**Application no:** H23-0876-10

**Description:** Proposed replacement dwelling

**Location:** The Bungalow  
Common Road  
Whaplode Drove  
Spalding Lincs  
PE12 0UF  
PE12 0UF

# AMENDMENT RECORD SHEET - LIVE APPLICATION

Drawing Number:
10/254/PA/003

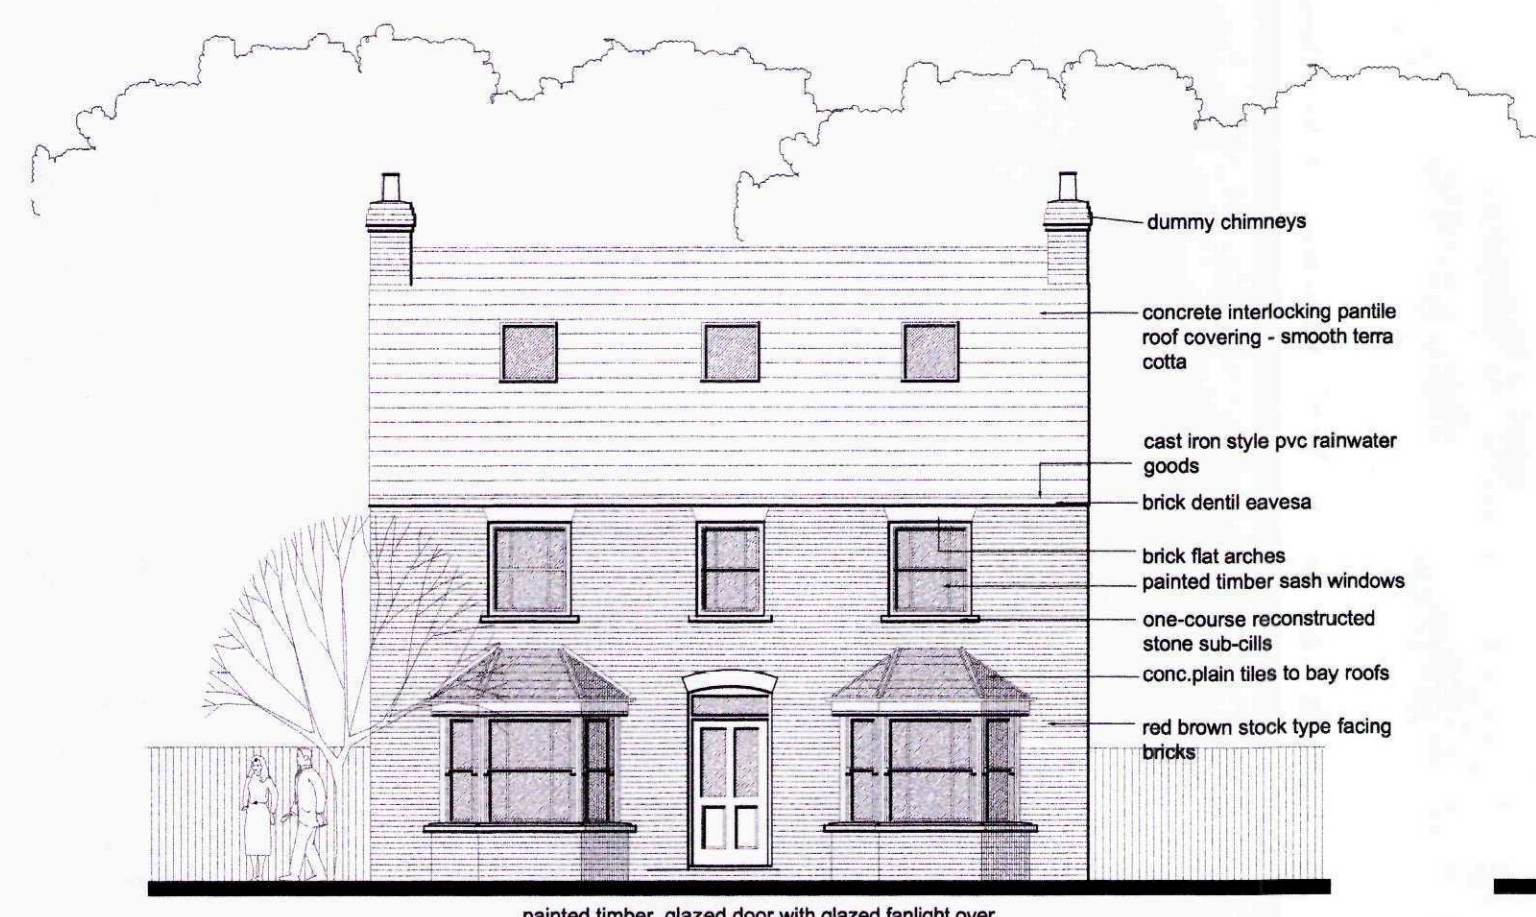
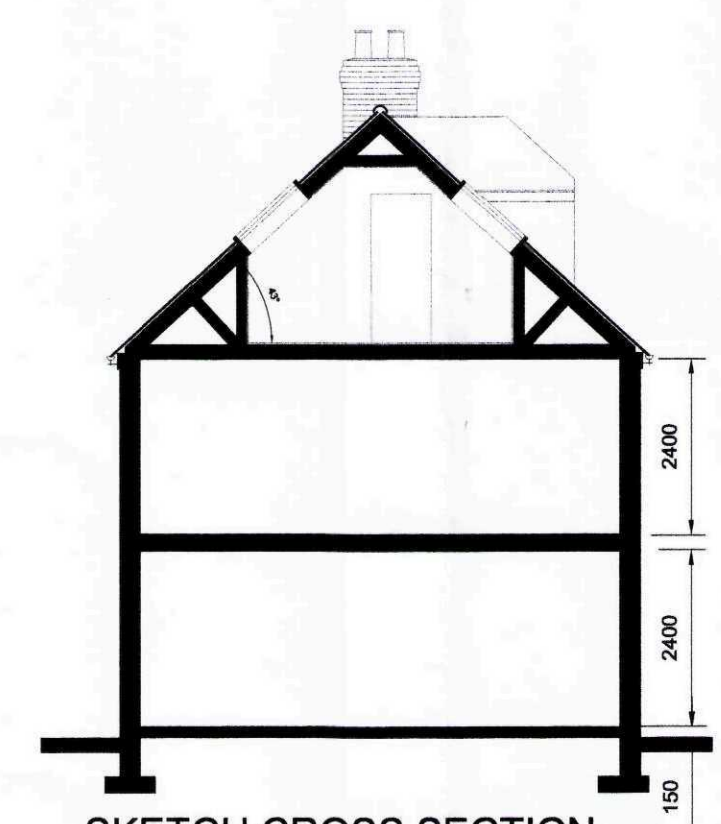
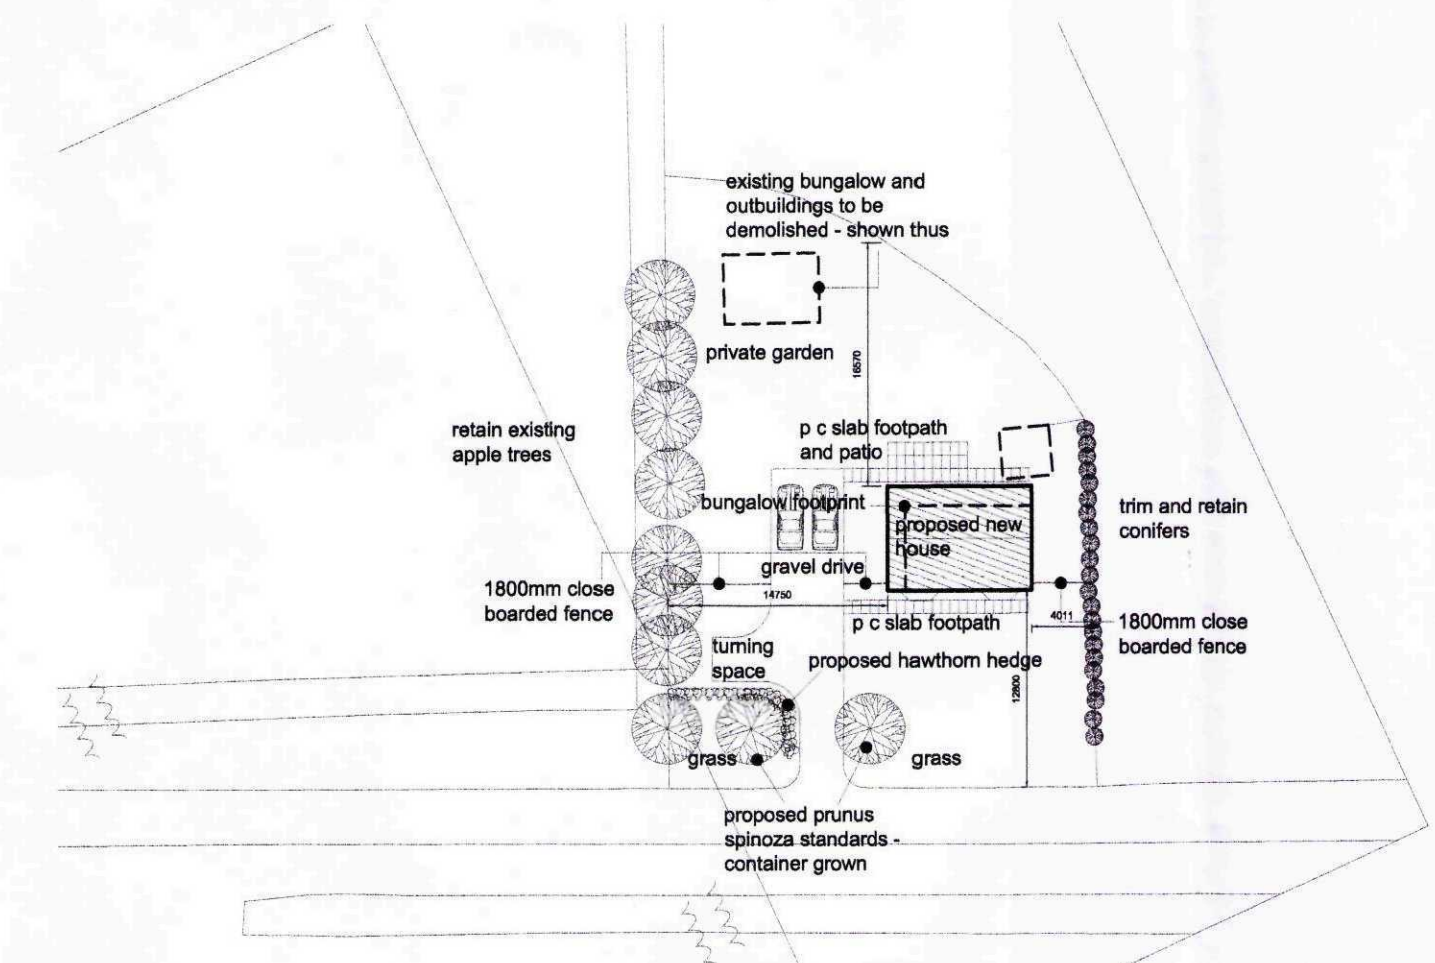
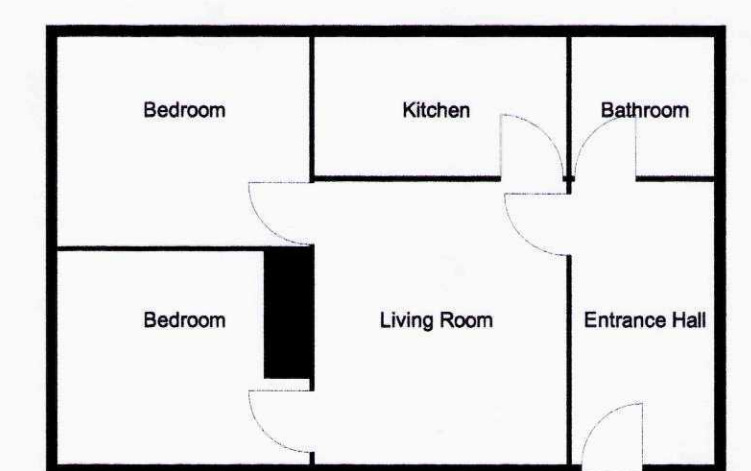
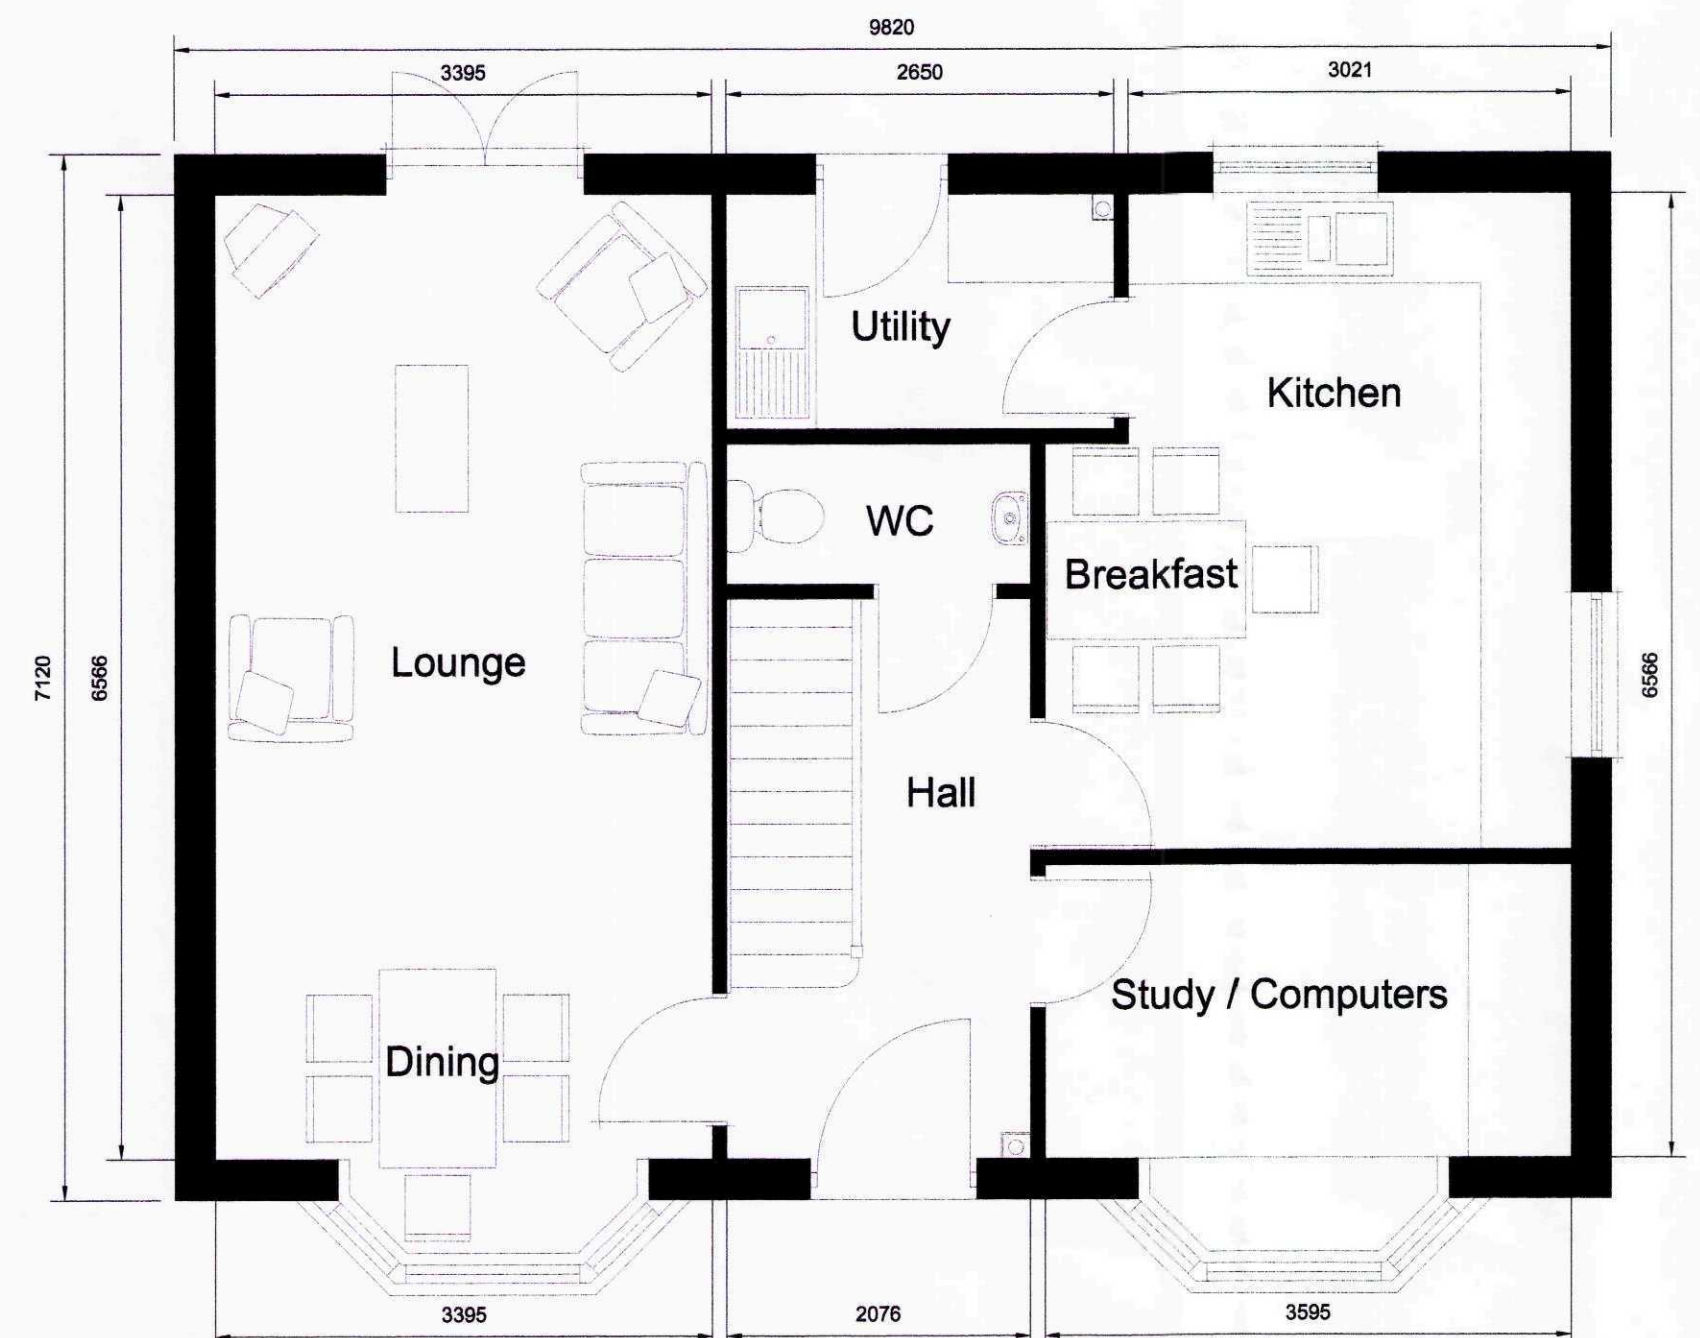
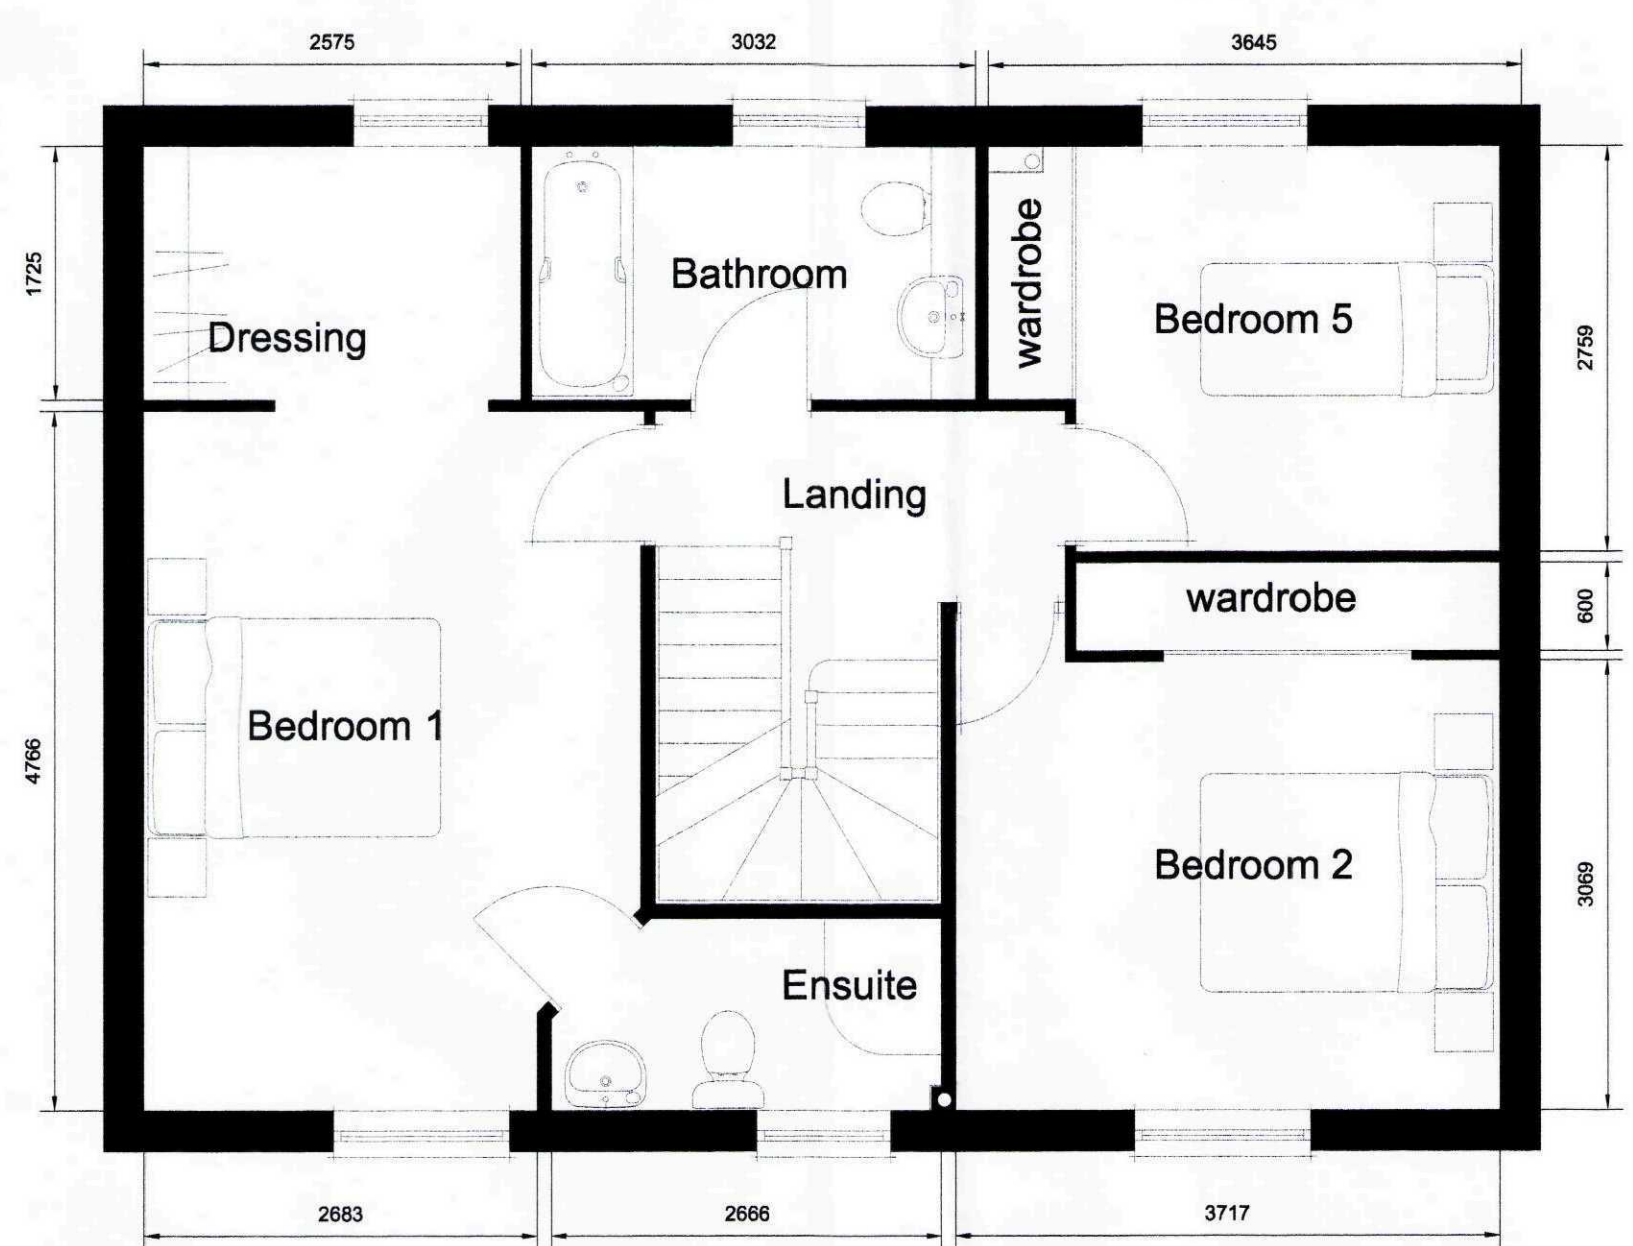
In accordance with the above, a number of revisions are therefore required to make the development more acceptable. The dormer at the rear in particular is unacceptable and should be omitted. The number of rooflights on the front elevation is also excessive - the middle one should be deleted. Whilst we are somewhat more relaxed in respect of the rear elevation, the window on the side elevation should have a greater vertical emphasis.

The external roofing material to be used for the main roof and bays will need to be a traditional material and not concrete.

I have now modified the drawing according to your wishes, and attach a copy for your comments. I believe that I have addressed the dormer issue and have reduced the Velux type windows also, taking them off the front elevation completely. I have added two small windows in the gables and trust that you will not have a problem with these. I have also changed the roof covering specification, and have slimmed down the ground floor gable window.
